Reference No:	2020/62/94196/W
Site Address:	78, Wellhouse Green, Golcar, Huddersfield, HD7 4ET
Description:	Erection of single storey extension to side (Listed Building within a Conservation Area)
Recommending Officer:	Sam Jackman

DECISION – Conditional Full Permission

Officer Report – Planning - 2020/94196

Proposed front elevation (1:100)

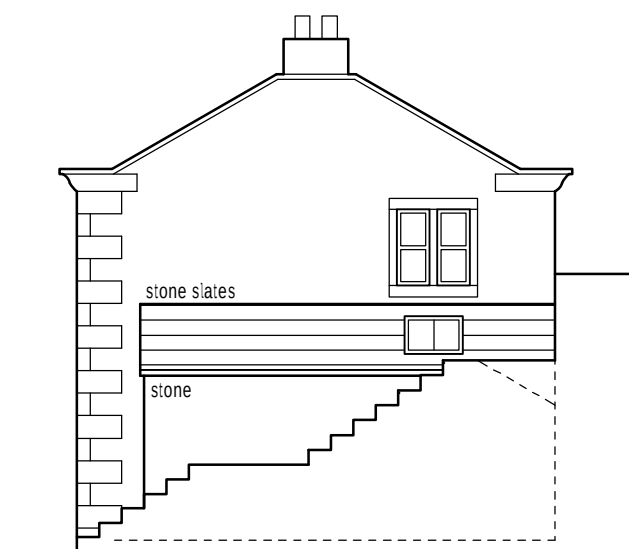
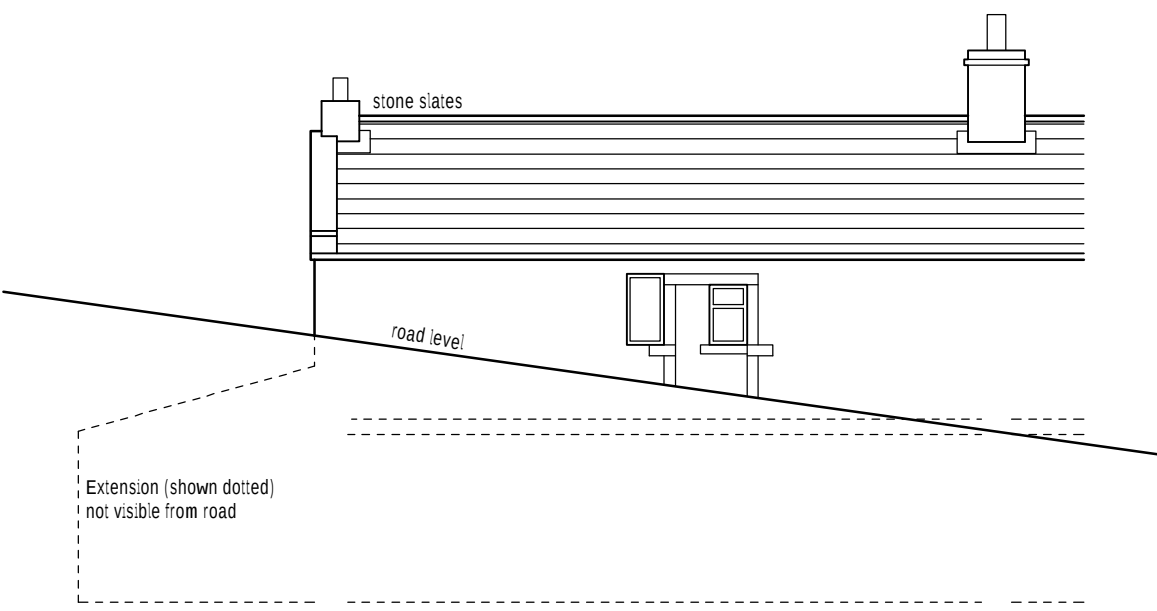
In 2009 a similar application was submitted which in principle was considered to be acceptable. However, there were concerns regarding the detailed design which would obscure the quoins of the existing dwelling, fenestration detailing with a central door and 3 large rooflights. Furthermore, the materials of construction with artificial stone slate roof and with double glazed windows. It was considered that the extension would have had a detrimental impact on the character and appearance of the conservation area and Listed Building, contrary to policy BE5 at the time.

The application as amended is of a similar size to the 2009 application, however, the front elevation has been set back 0.9m to retain the quoins, the fenestration details reflect the existing extension with a single window to the right of the entrance and with only 1 roof light. Materials proposed are natural stone with a stone slate roof.
